October 20, 2023

To: City of Albuquerque Planning Department  
Plaza del Sol Building  
600 Second NW  
Albuquerque, NM 87102

Re: **ALLSUPS #102460**  
**Project #: PR-2021-006208**  
**Application #: SI-2023-01171**

Please find the following responses addressing comments received in a letter dated September 20, 2023. In an effort to address your comments concisely and simplify your review of these development plans, we have summarized your comments and our responses below. Your comment is listed first, followed by the response in Bold.

LANDSCAPE PLAN

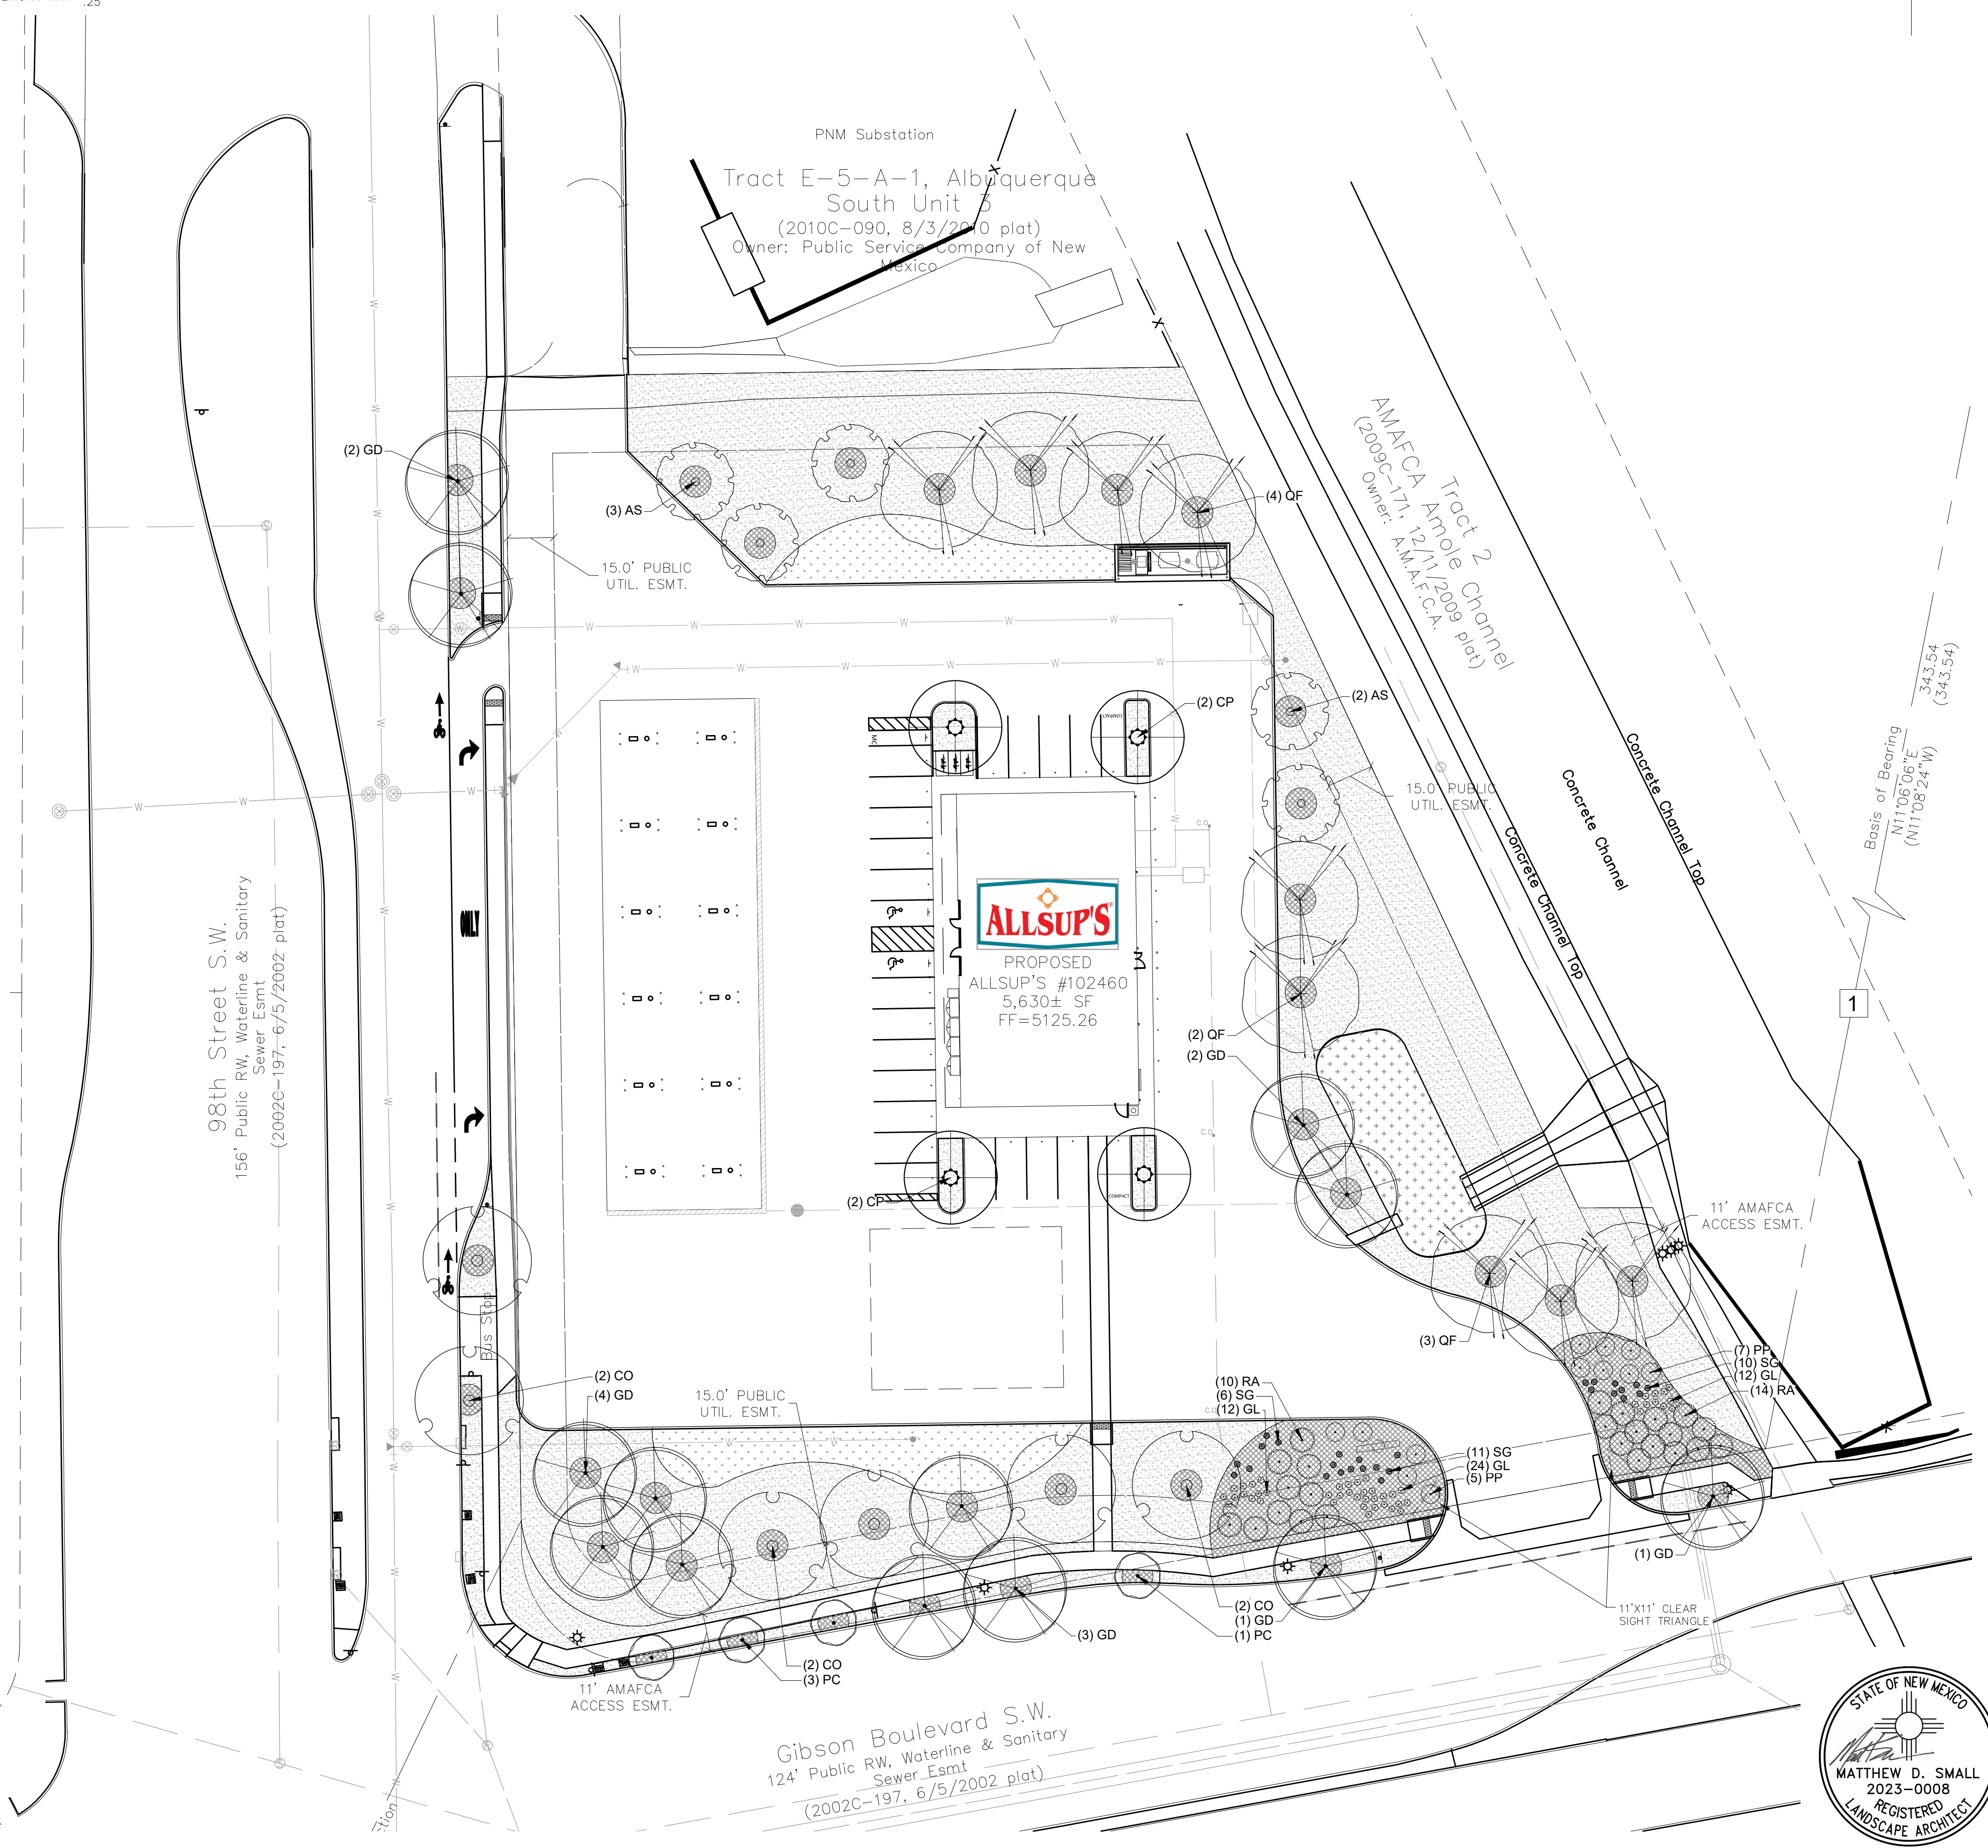
Comment 2: IDO requirement 5-6(C)(5)(e) Organic mulch is required as ground cover under trees within a 5-foot radius around the tree trunk, but not directly against the trunk is being met per Landscape General Notes.

**Response 2: Ground cover is meeting the requirements of IDO 5-6(C)(5)(e). See Landscape Detail sheet in the Landscape Planting Specifications section, Bullet point 4.**

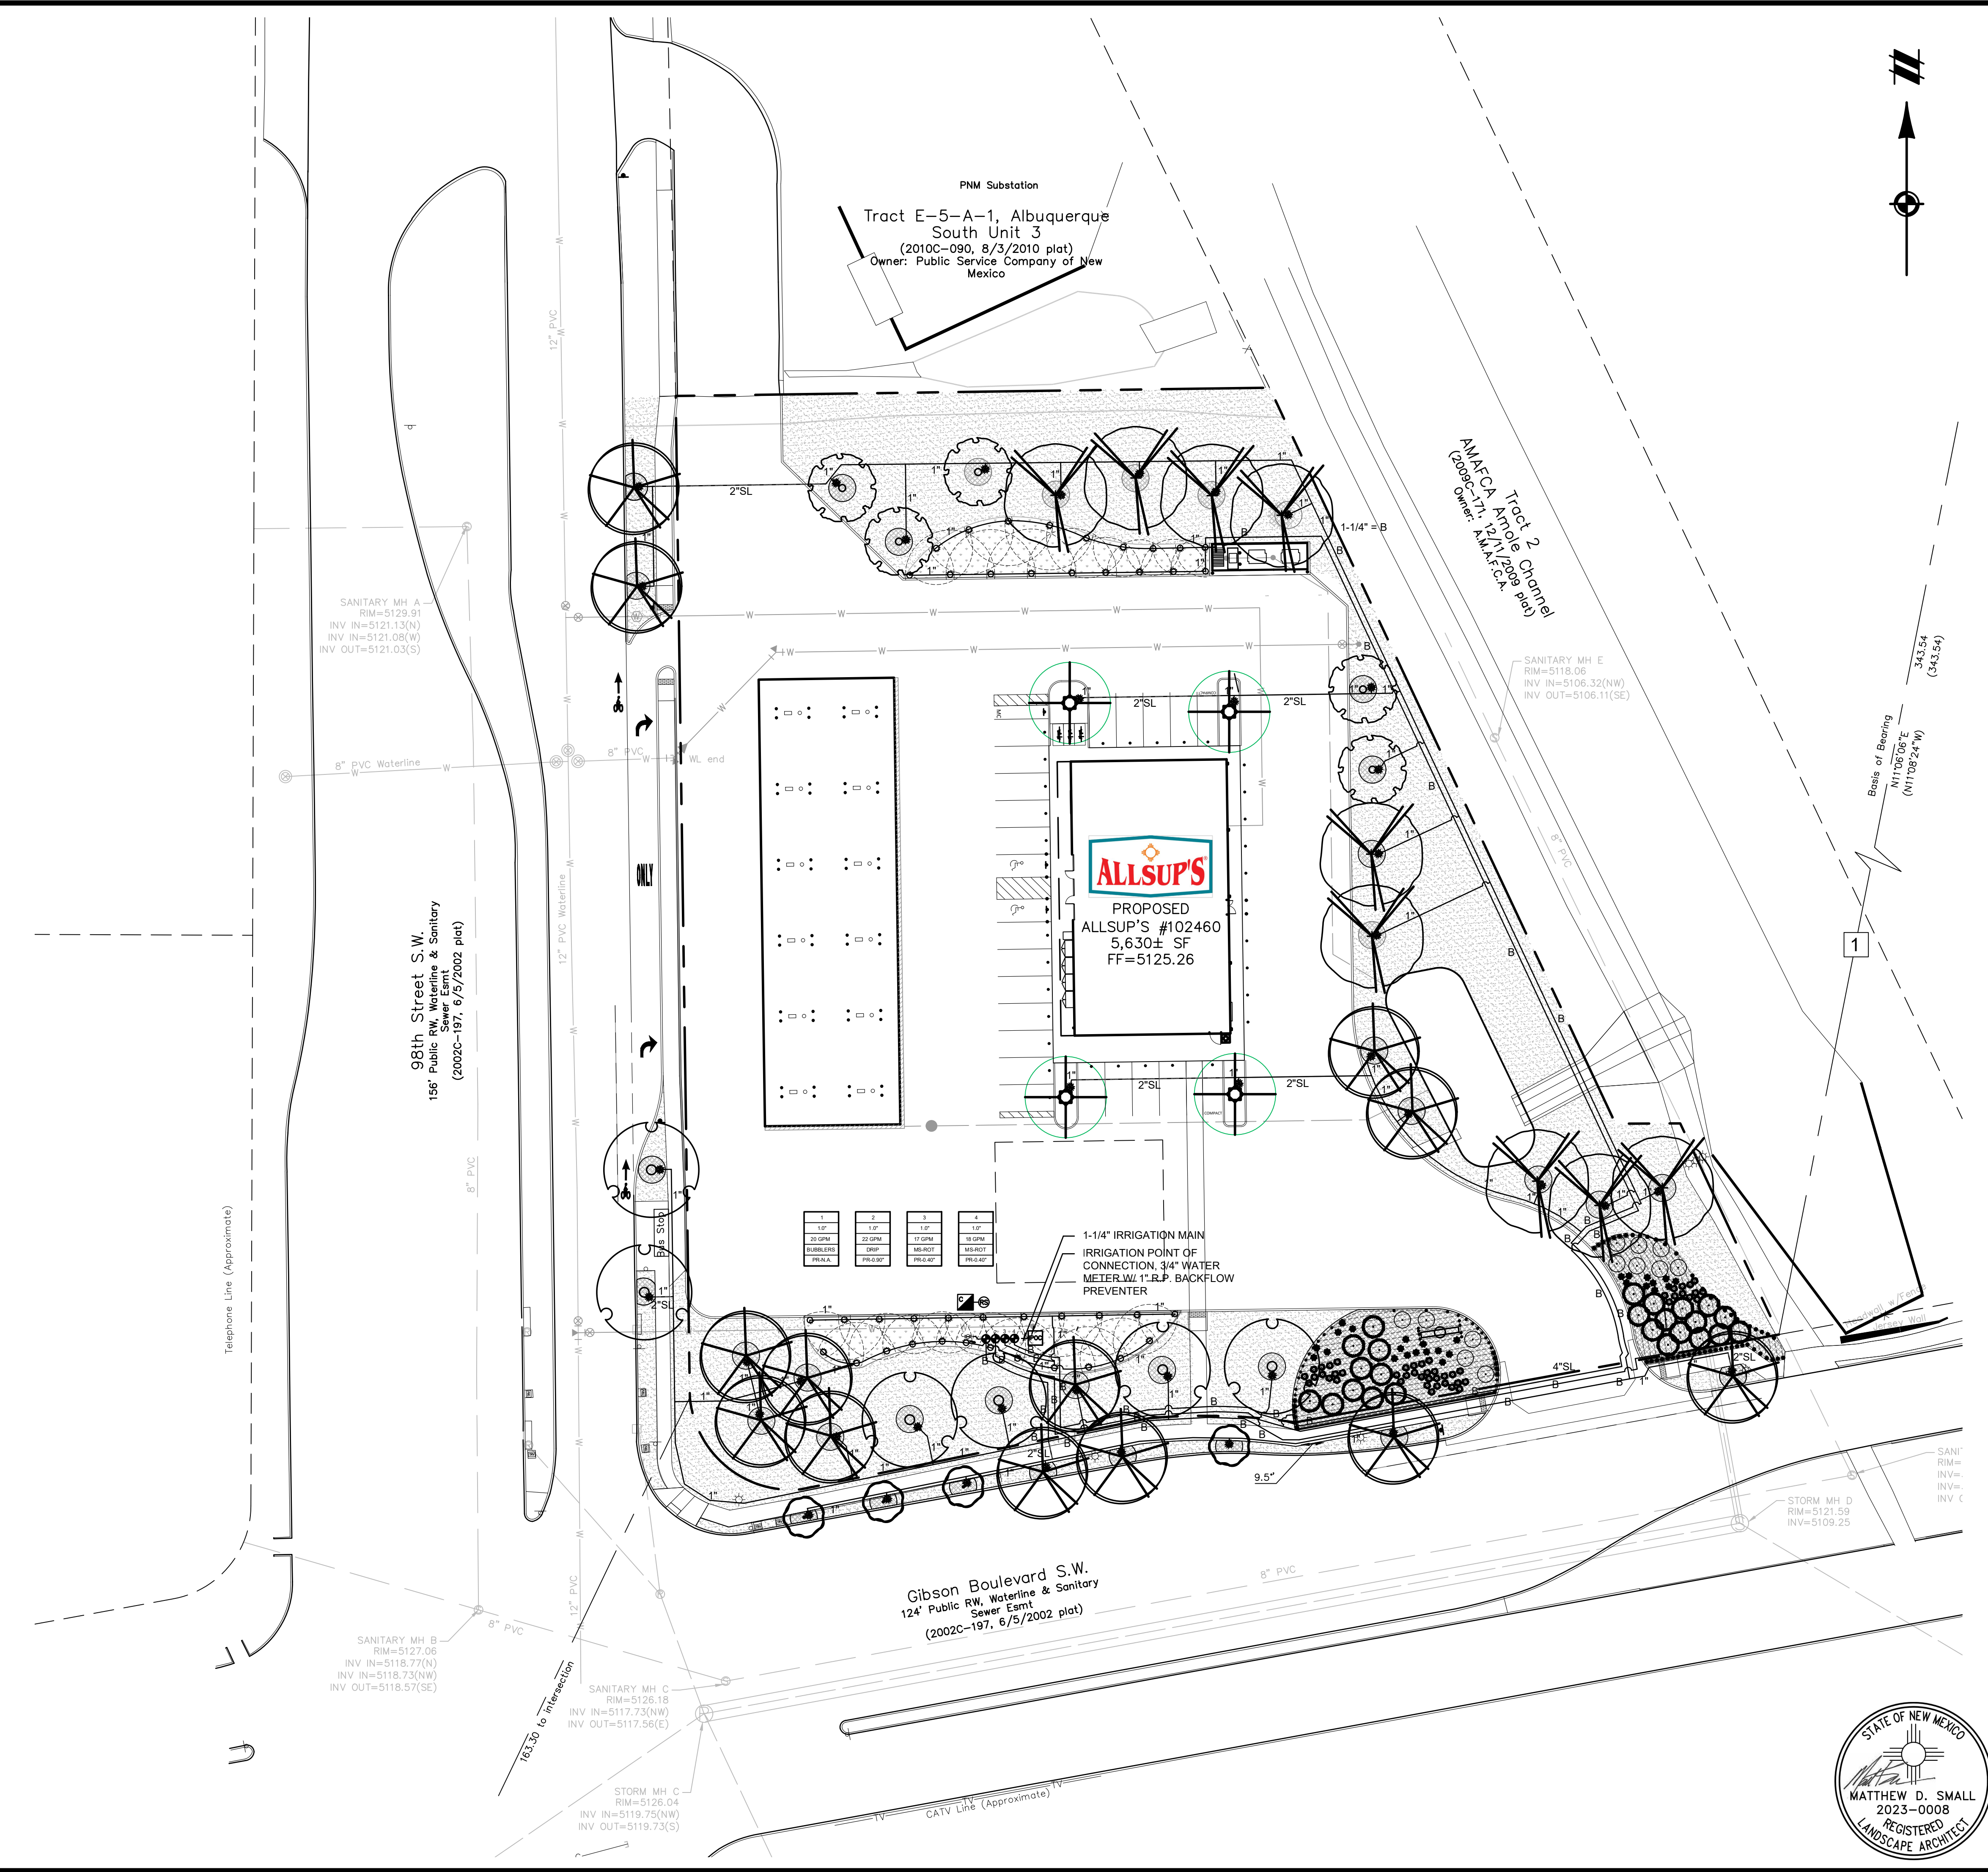
Comment 4: Per IDO 5-6(C)(14) Irrigation Systems 5-6(C)(14)(a) Irrigation systems shall comply with Section 8 of the ABCWUA Legislation and Ordinances (Cross Connection Prevention and Control Ordinance)  
[https://www.abcwua.org/wpcontent/uploads/Ordinances\\_PDFs/Section\\_8\\_Cross\\_Connection\\_Prevention\\_and\\_Control.pdf](https://www.abcwua.org/wpcontent/uploads/Ordinances_PDFs/Section_8_Cross_Connection_Prevention_and_Control.pdf)

**Response 4: The irrigation plan meets the standards. IDO 5-6(C)(14)(a) and ABCWUA Section 8 are met. An approved backflow preventer is proposed at the point of connection.**
